WEST SUSSEX COUNTY COUNCIL CONSULTATION

TO:	Arun District Council FAO: Andrew Wood
FROM:	WSCC - Highways Authority
DATE:	3 April 2019
LOCATION:	Land Adjacent to Elm Lodge, Tamarisk Way, Ferring, West Sussex
SUBJECT:	FG/220/18/PL Erection 1 No. dwelling with integral garage. Amended plans received.
DATE OF SITE VISIT:	N/A
RECOMMENDATION:	Advice
S106 CONTRIBUTION TOTAL:	N//A

Drawing Title PROPOSED GROUND AND
FIRST FLOOR PLANS

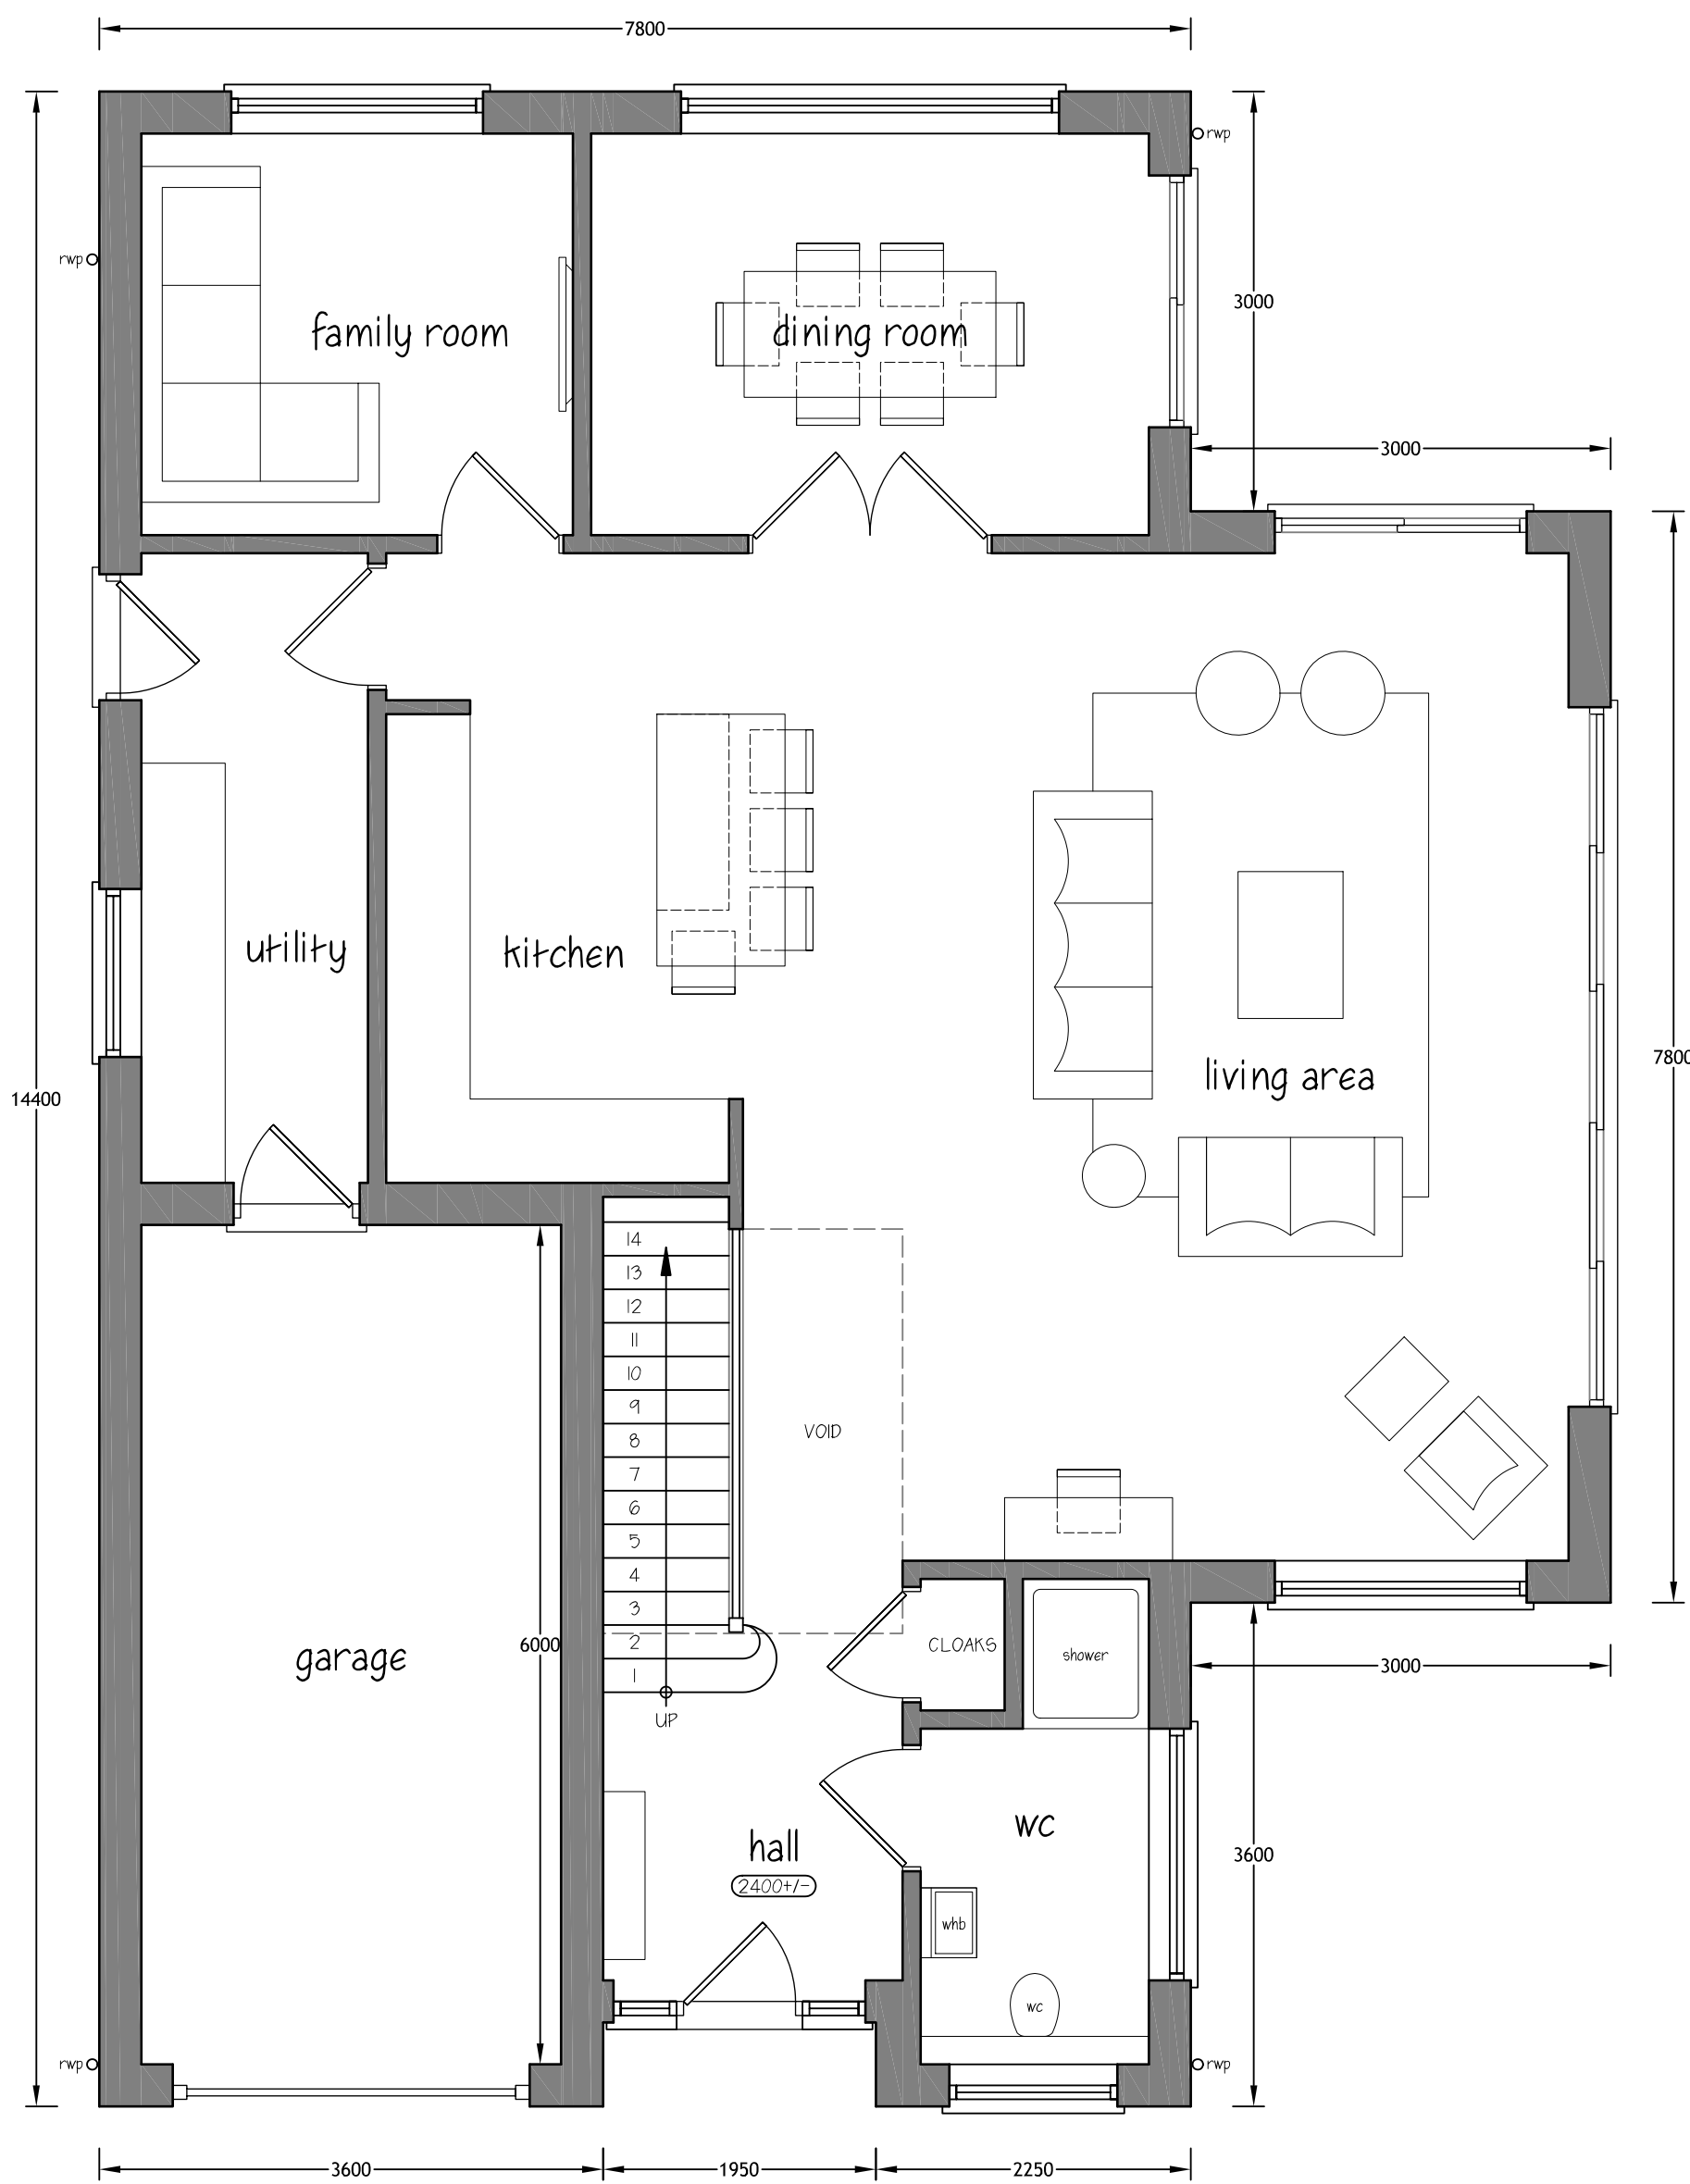
The proposed plans indicate that two off-street parking spaces will be provided for the proposed dwelling and an integral garage. The revised plans demonstrate internal garage dimensions of 3 x 6m, as recommended by the LHA in our previous response. The garage can now be counted as a third parking space for the proposed dwelling. This level of parking provision is anticipated to be sufficient for a dwelling of this size and location. A turn on site would be preferred however there is clearly insufficient space on site to accommodate this. However, neighbouring properties have similar arrangements and operate without evidence of safety concern.
